From: Liz Annalls [REDACTED]
Sent: 11 January 2021 07:22
To: Planning.Responses <Planning.Responses@arun.gov.uk>
Subject: RE: Planning Consultation on: Y/151/20/PL

Application No: Y/151/20/PL
Site Address: Pollards Nursery Lake Lane Barnham PO22 0AD
Description of Works: Permanent siting of temporary seasonal horticultural worker' accommodation (8 mobile homes & 3 retrospective mobile homes), hardstanding & service building. This site also lies within the parish of Barnham, is in CIL Zone 3 (Zero Rated) as other development.

Scheme **Eric Wall Nursery, Lake Lane, Barnham, PO22 0AD**
Title **Proposed Site Plan (2 of 2)**

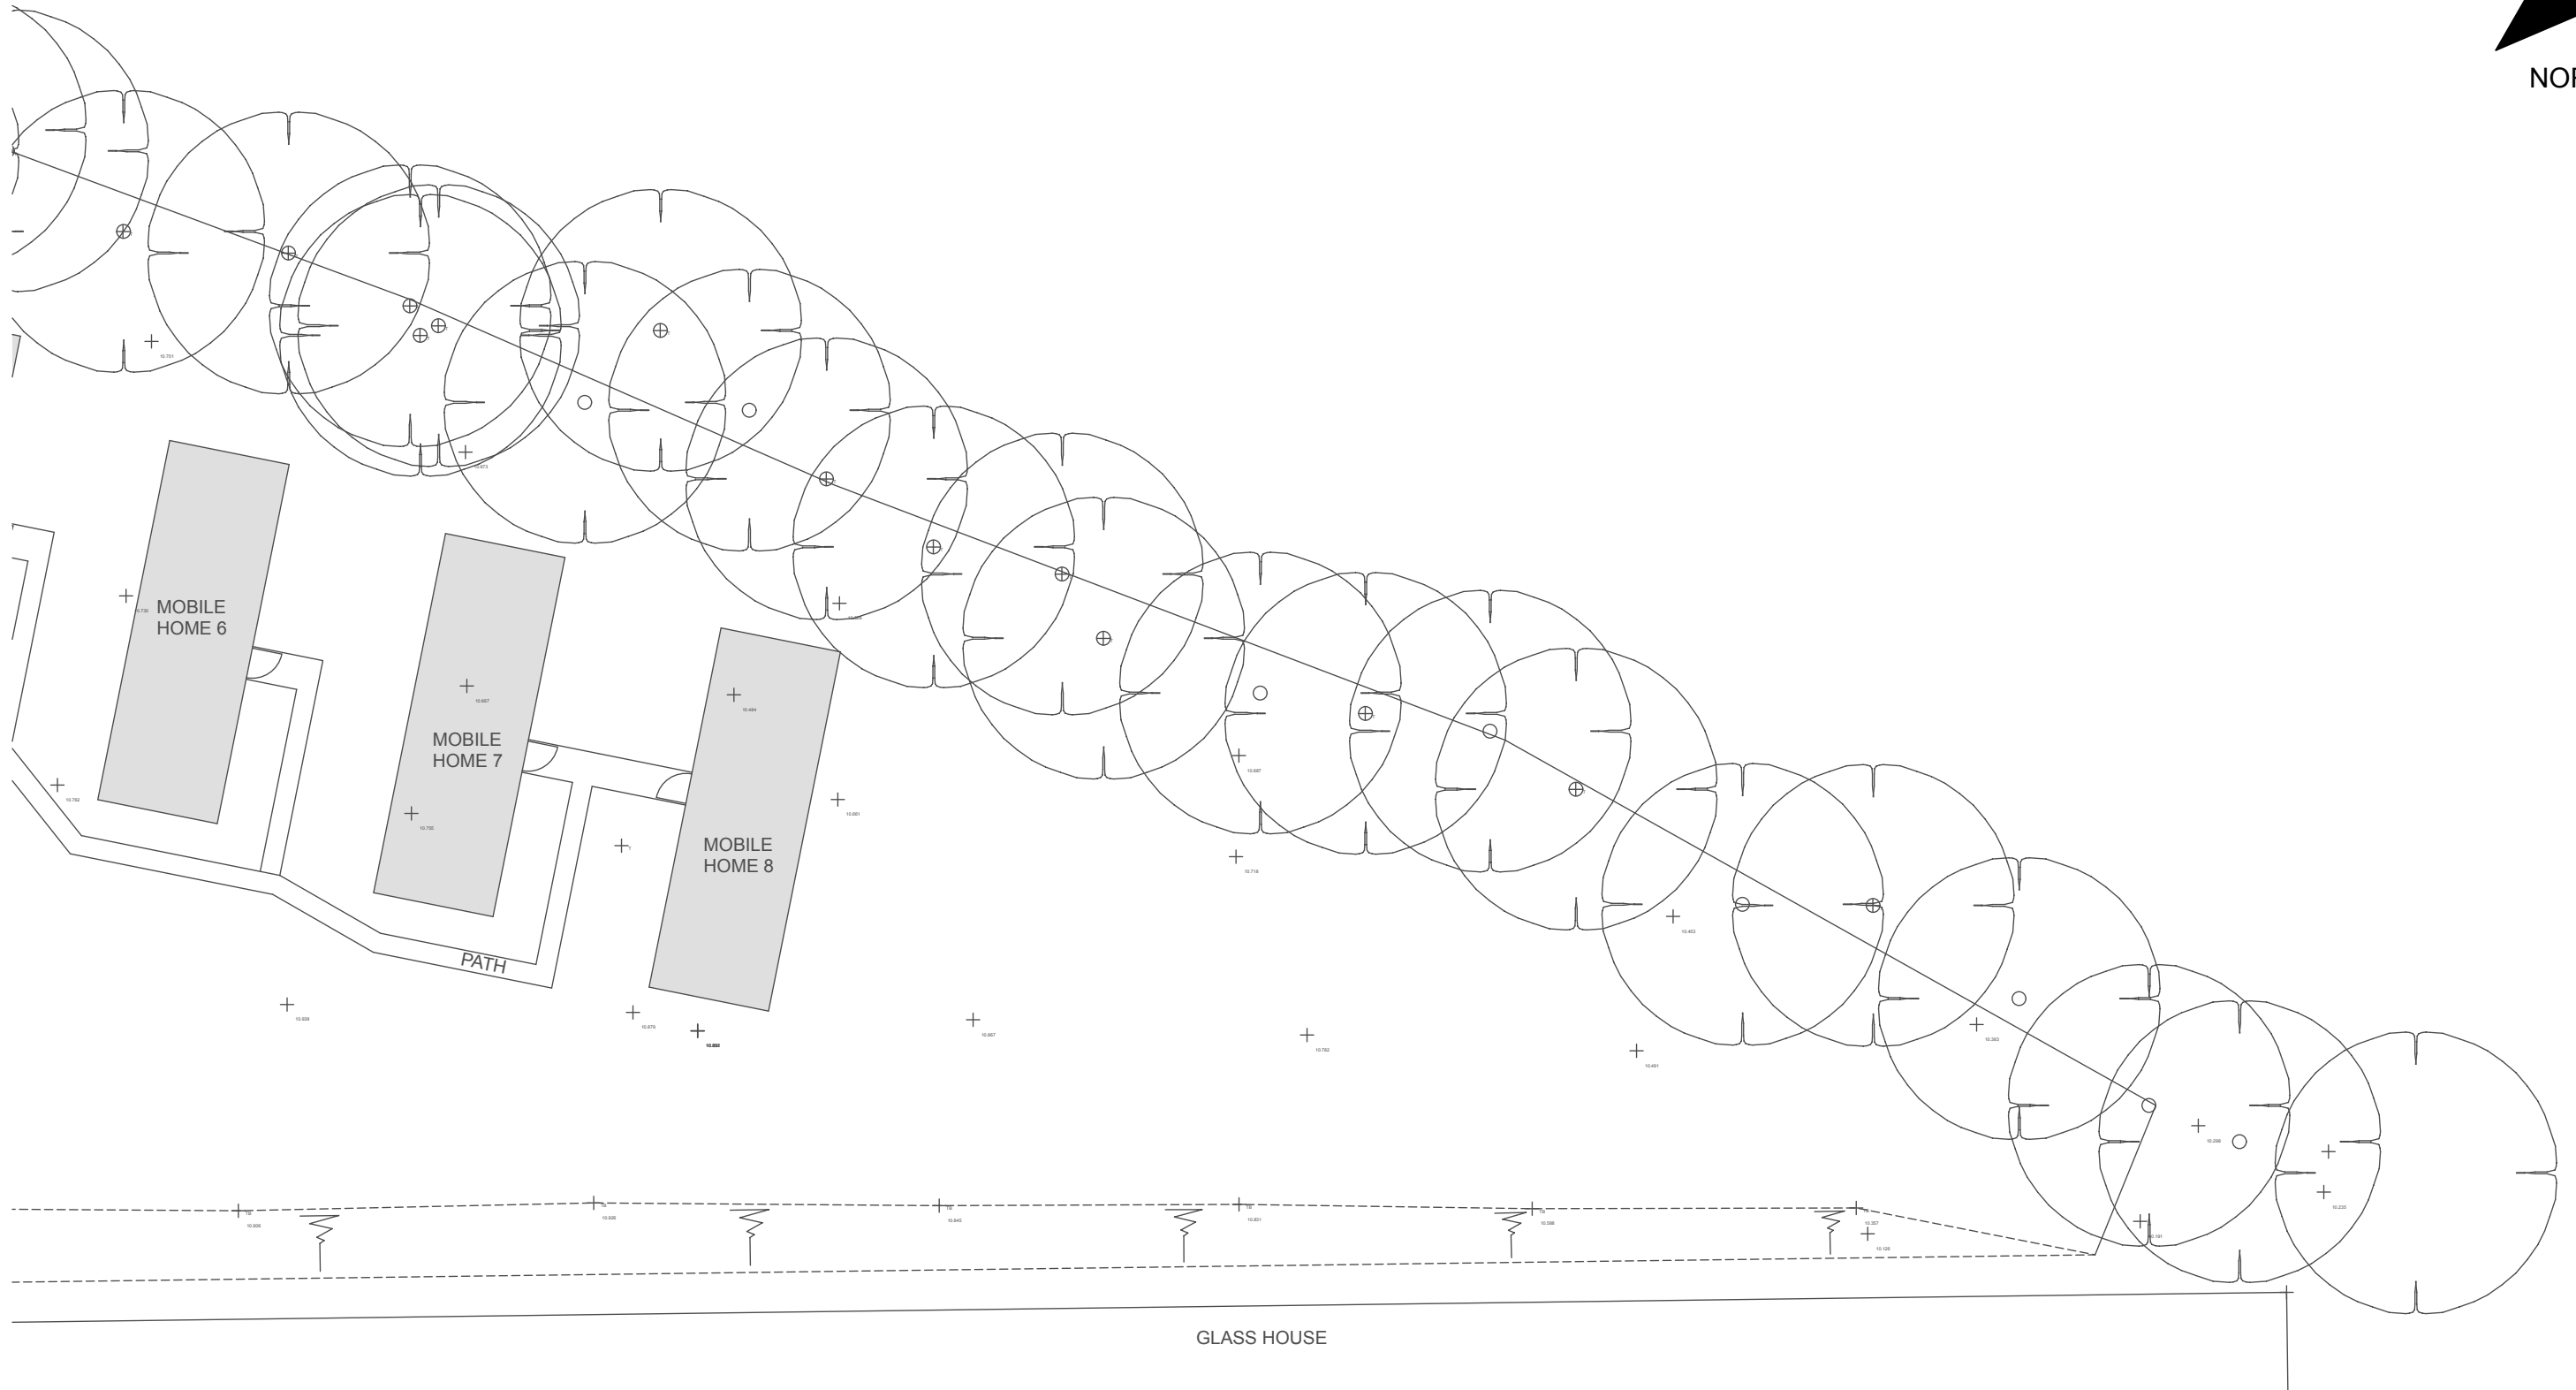
The hedgerows on site are used by bats, and potentially dormice, reptiles and Great crested newts for nesting, commuting and foraging and will need to be retained and enhanced. This will include having a buffer strip around the hedgerows (5m) and during construction fencing should be used to ensure this area is undisturbed. Any gaps should also be filled in using native hedge species to improve connectivity. Conditions should be used to ensure this.

The lighting scheme for the site will need to take into consideration the presence of bats in the local area and the scheme should minimise potential impacts to any bats using the trees, hedgerows and buildings by avoiding unnecessary artificial light spill through the use of directional light sources and shielding.
